3 e) Signage Strategy

City of Sydney Comment - 3 e)

FIGURE 15 | PRECINCT WAYFINDING

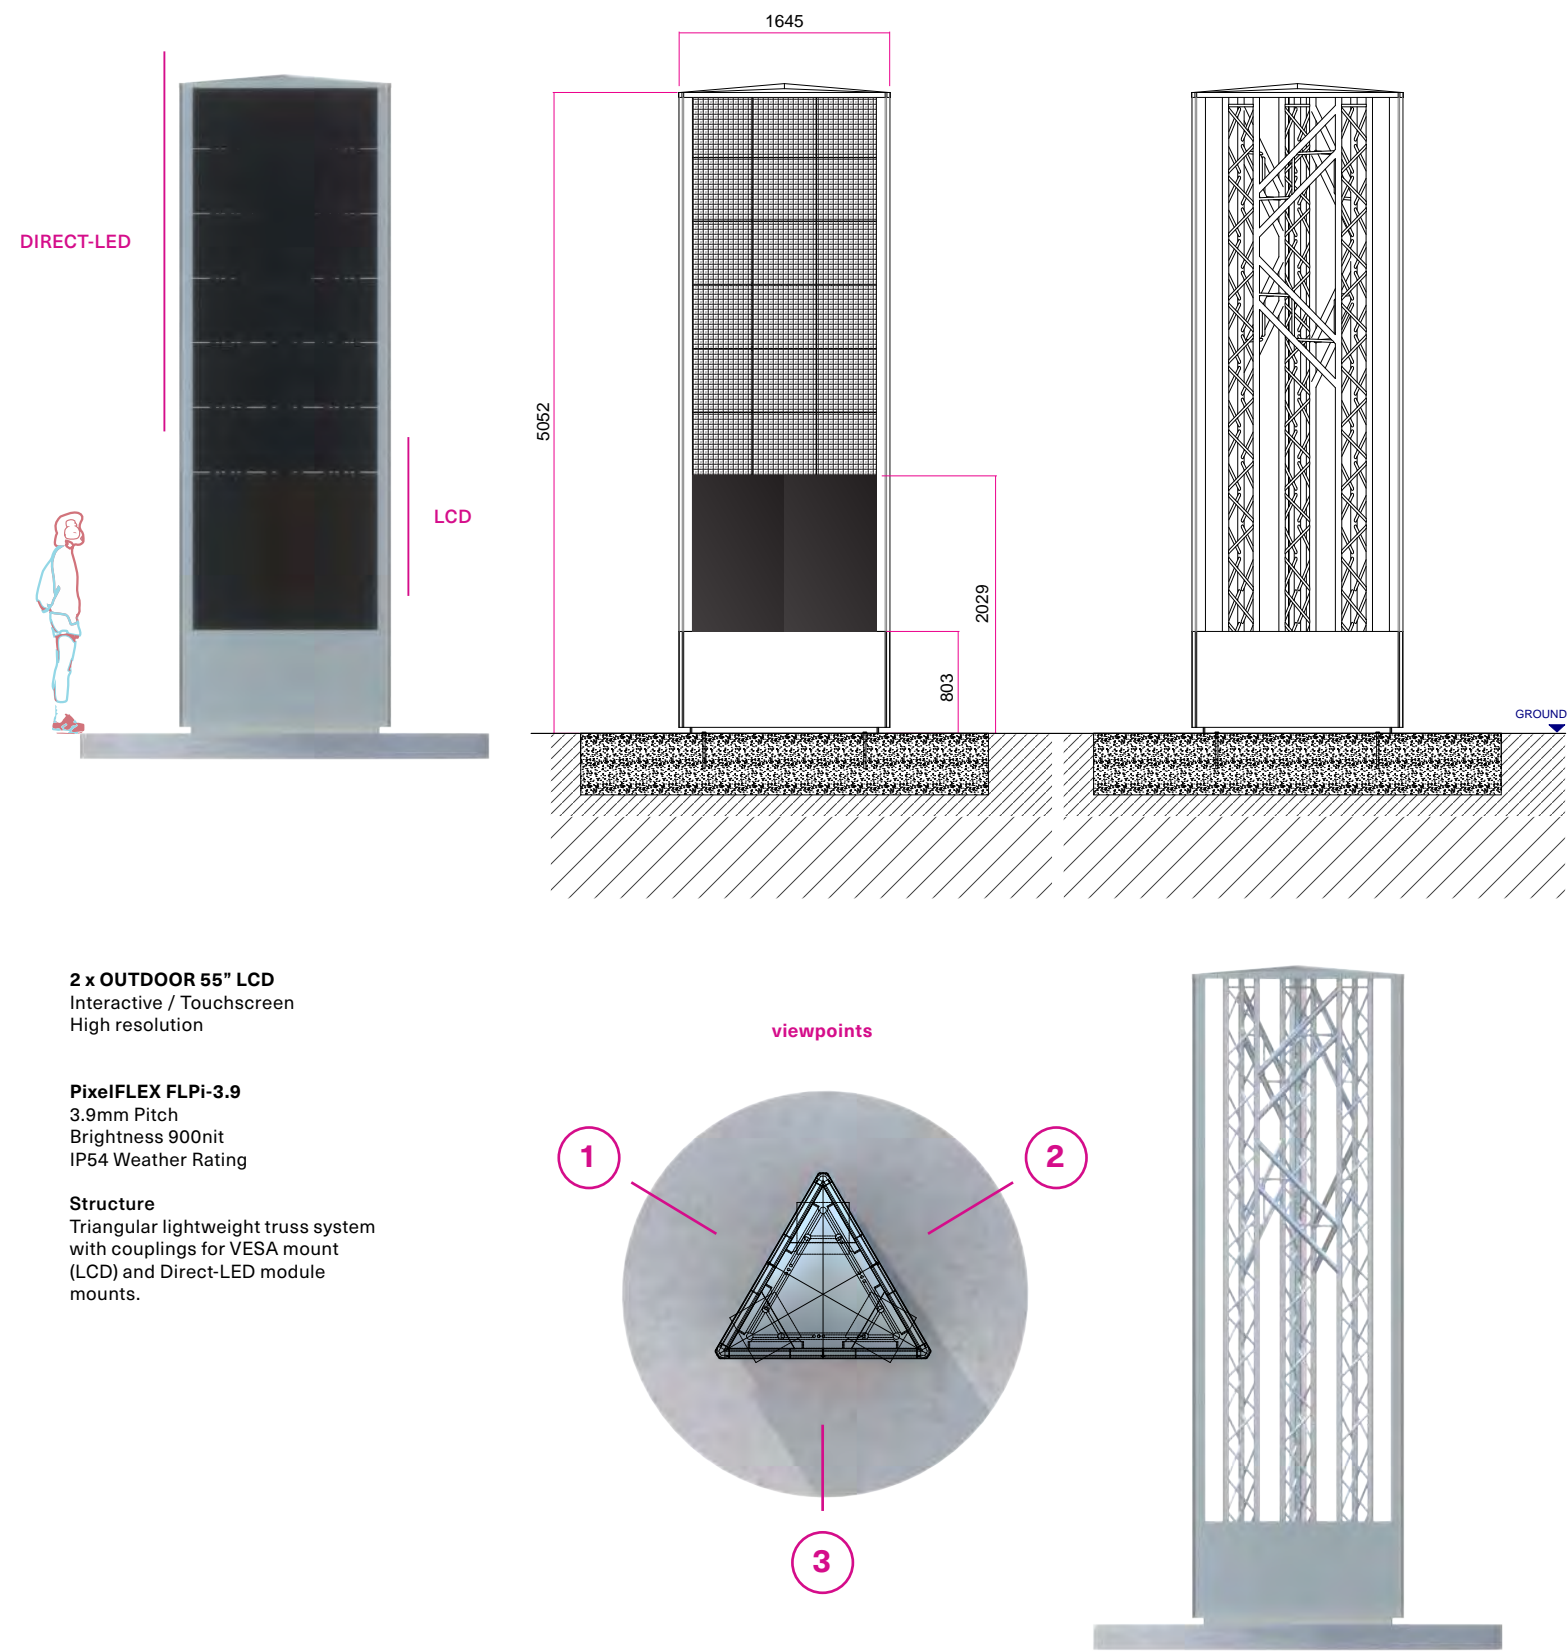
Any proposal for signage should be subject to a comprehensive signage strategy prepared with the input of the nominated heritage consultant and subject to a separate development application to the City of Sydney Council.

A Signage and Wayfinding Strategy, prepared by Urban & Public, accompanies the proposal. It advocates signage that is consistent in design, is of a high standard of materials, construction and graphics and is appropriately located. The building identification and wayfinding signage will be visually consistent and respect the integrity of the industrial character of the Walsh Bay Wharf precinct.

An overview of the signage and wayfinding concepts approval is sought for is outlined in the response to 3 a), Figure 15.

The Applicant will develop the detailed design of signage and wayfinding in consultation with the project's heritage consultant, the NSW Heritage Council and City of Sydney.
